**Consultation Response from KC, Highways Development Management (HDM)**

**2022/92471 Heckmondwike Hub Bus Station, Royle Fold, Heckmondwike, WF16 0HW**

**Redevelopment of Heckmondwike Bus Station including a new concourse building with waiting room, Changing Places WC, driver offices, 6 No. bus stands, landscaping, and associated works**

**RECOMMENDATION: Further information required**

TITLE: 12m RIGID TRUCK TRACK ANALYSIS

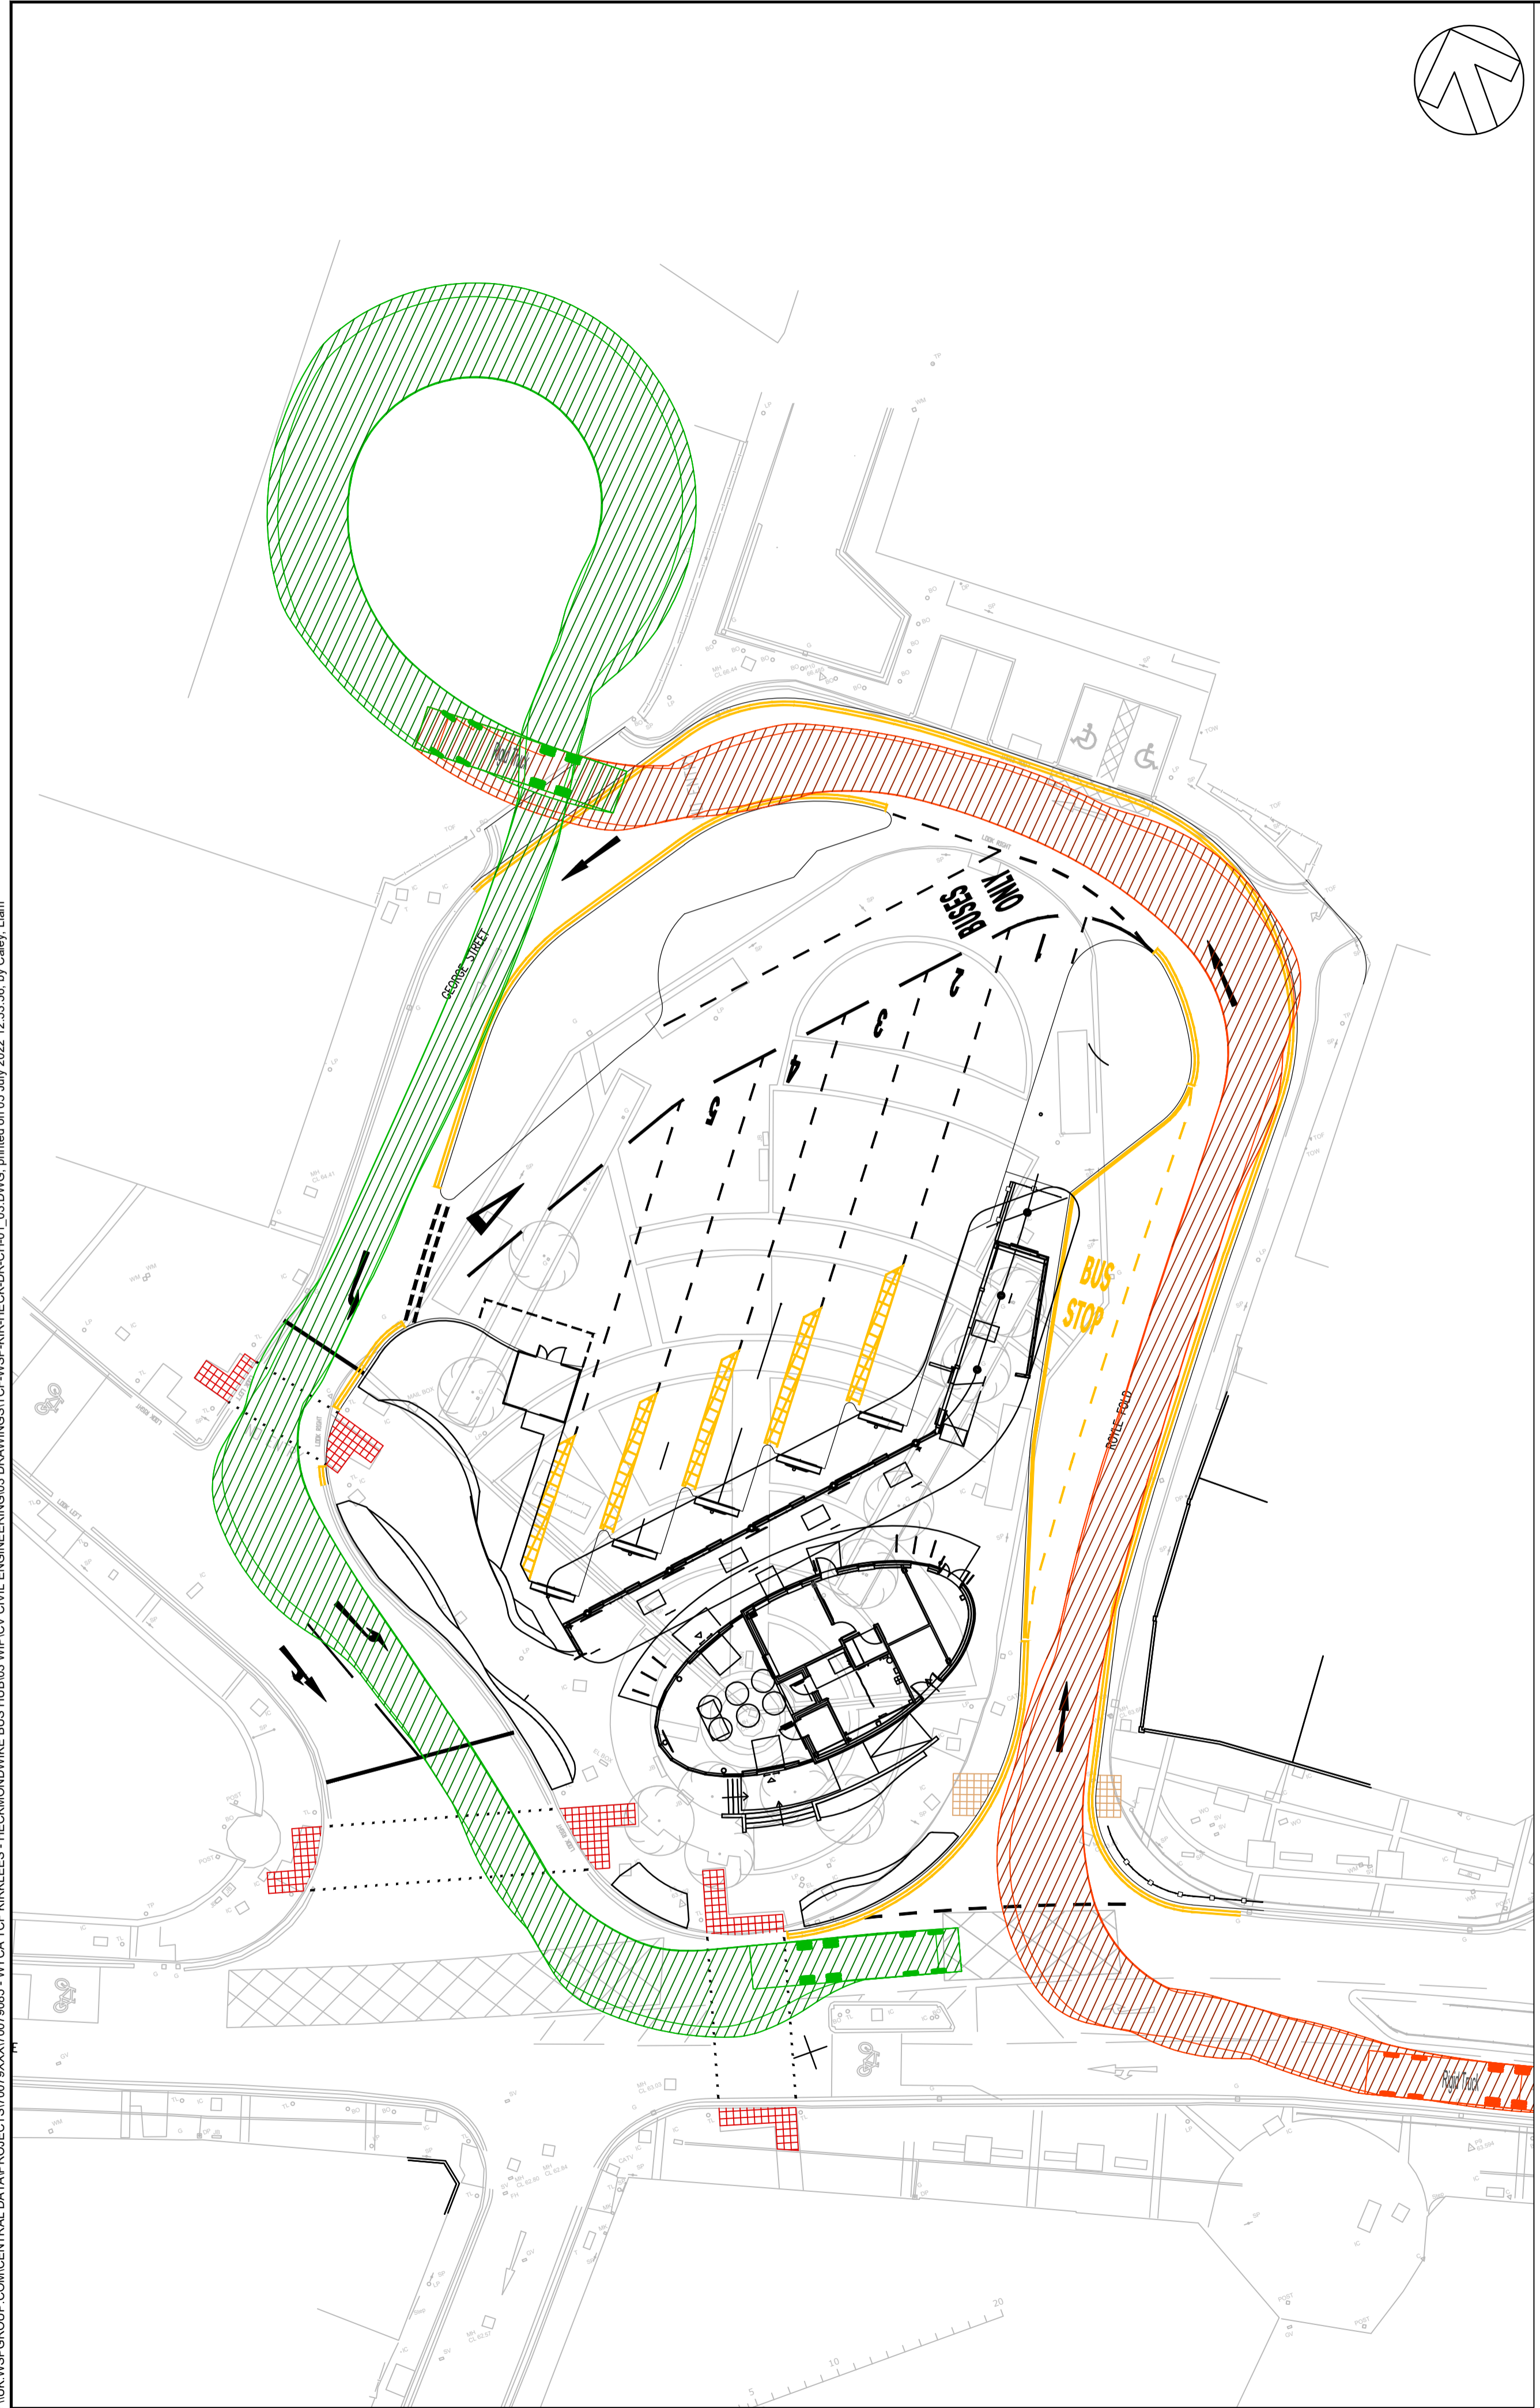
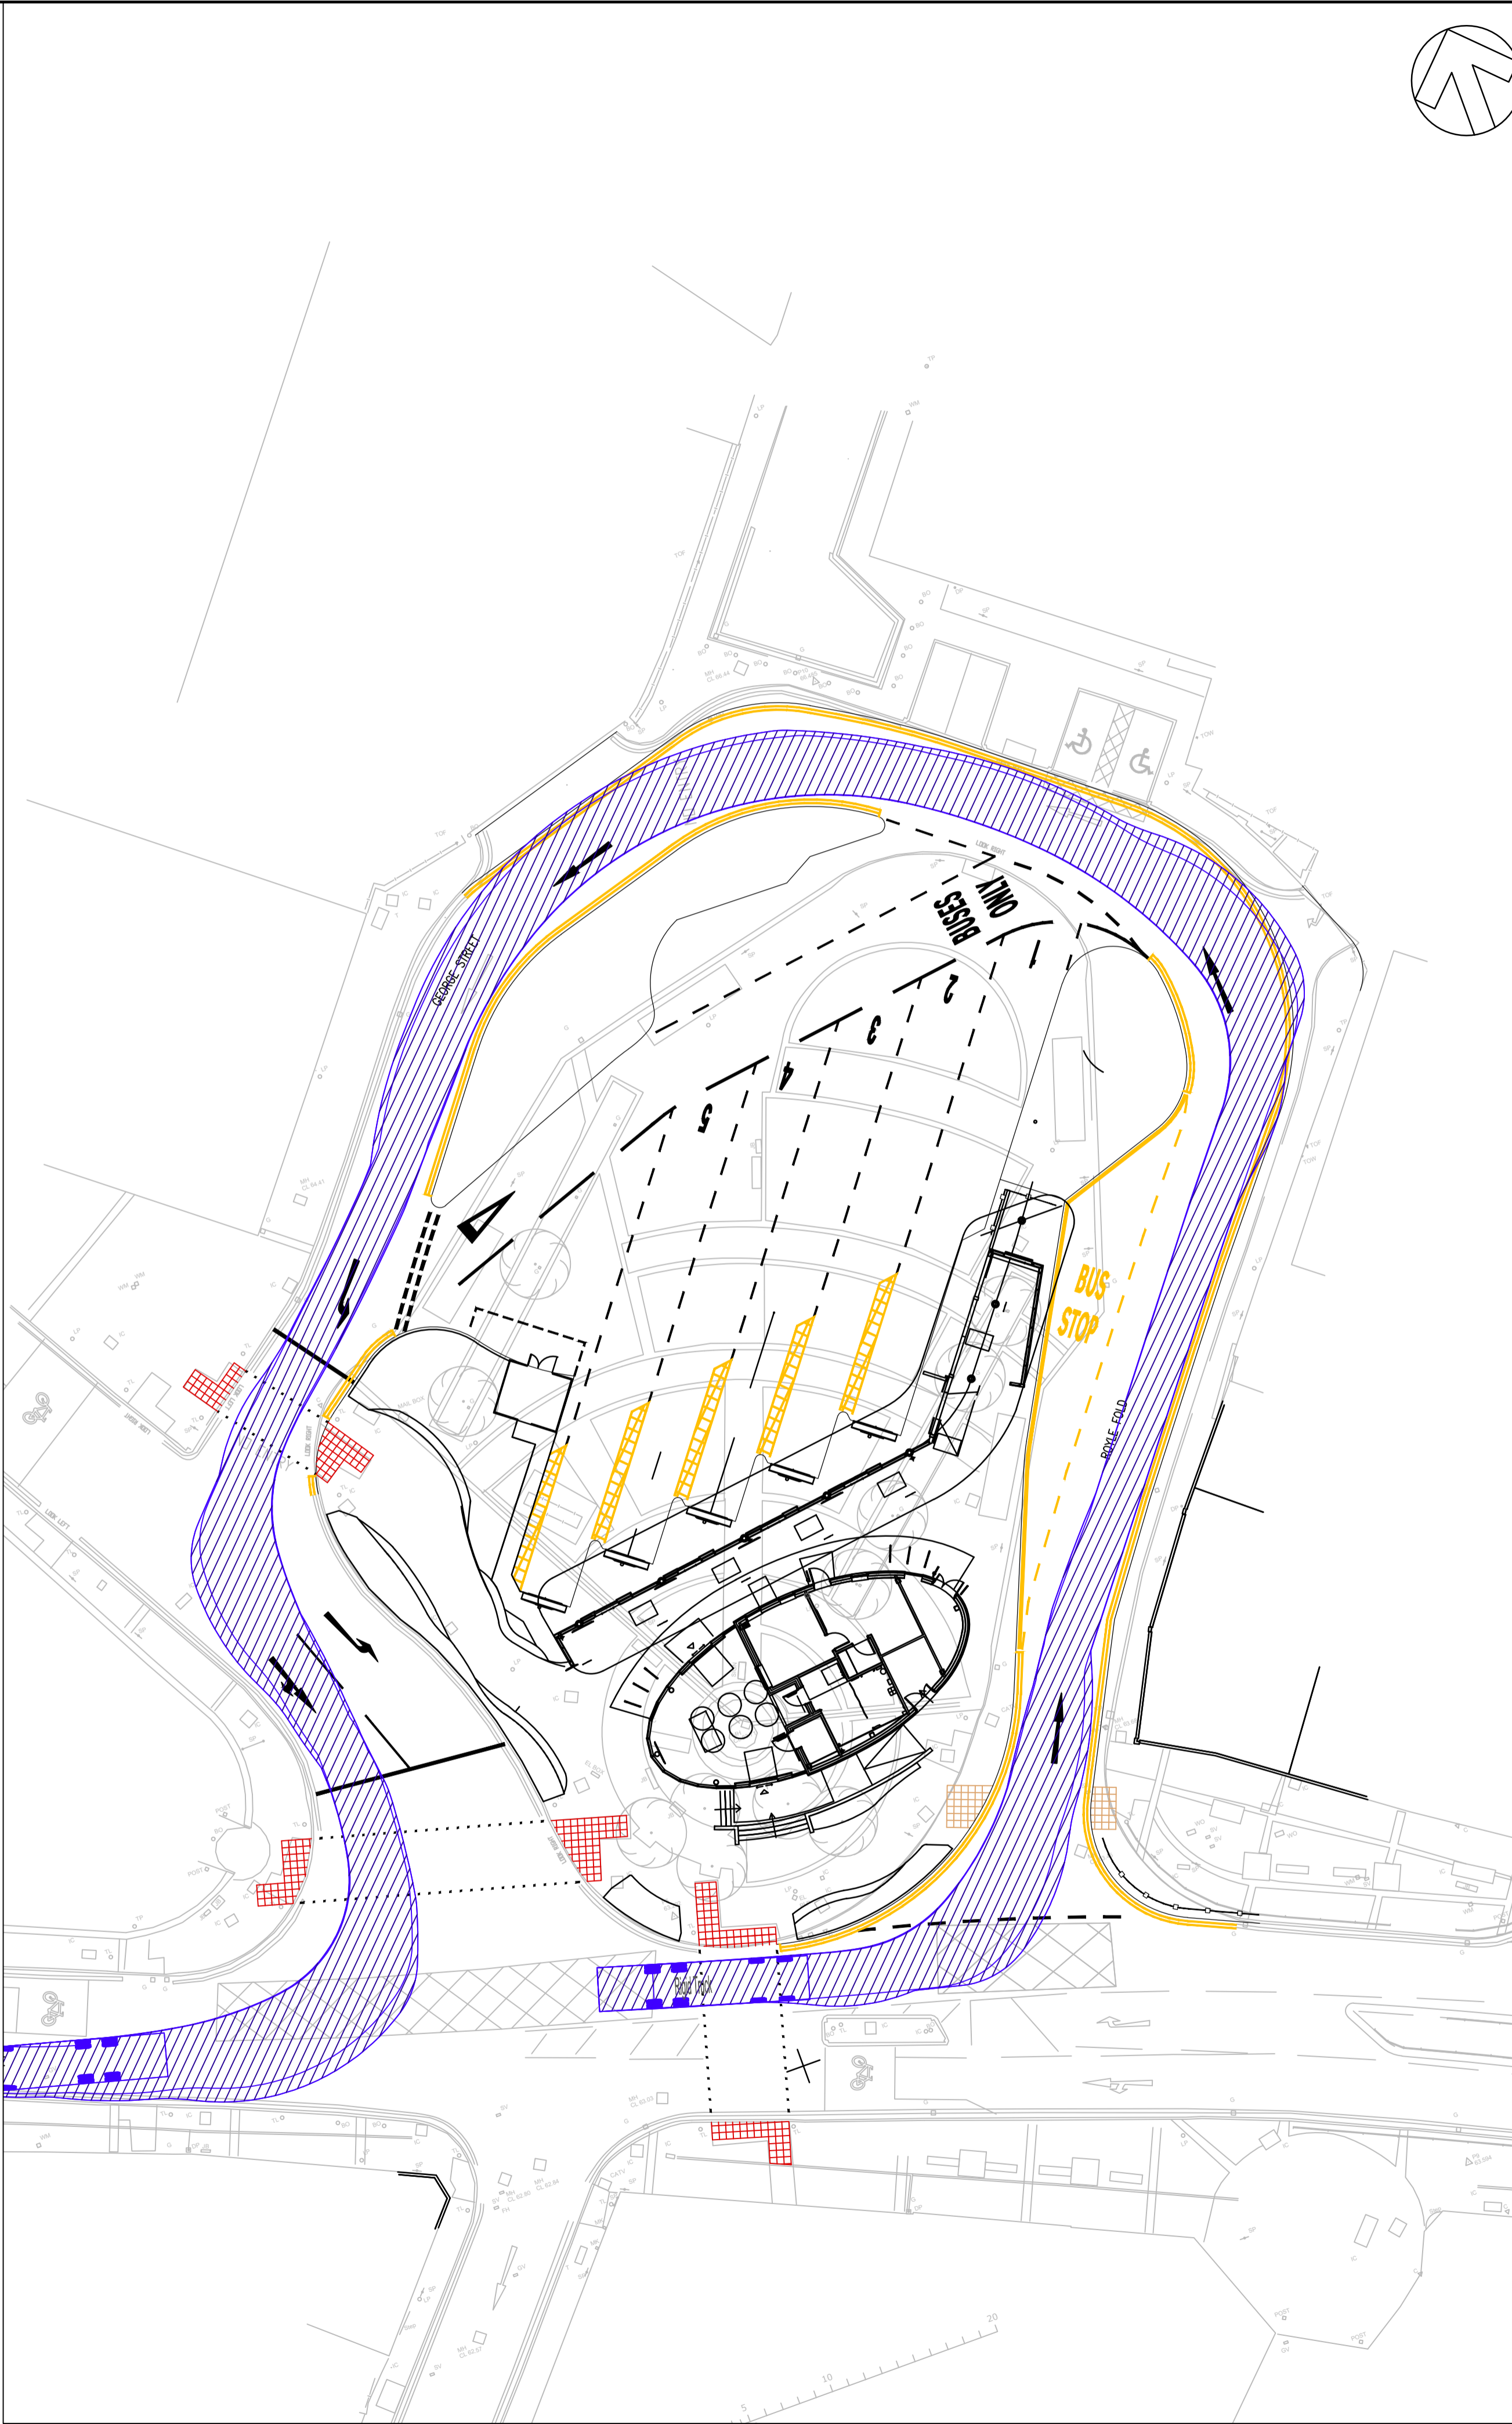
- It is unclear how bin collections will be managed and the type of vehicles that will be used for collection, as at present the bin store vehicle waiting area looks very small, and does not appear to be accessible without driving over the bus stands No. 1-5. Therefore, in addition to providing further SPA, further consideration of how bin collections will take place and be managed is required. It is noted that detailed comments have been provided by the Councils Waste Strategy Team, which have been provided at the end of this response.
- It is unclear whether the dentist access will still be able to accommodate refuse vehicle access following the narrowing of Royle Fold. Therefore, SPA is required to confirm that a refuse vehicle can still service this site.

Access/ sweep path analysis should recognise the dimensions and weight of waste collection vehicles and that parked vehicles could obstruct the route through the site and access to bin store.
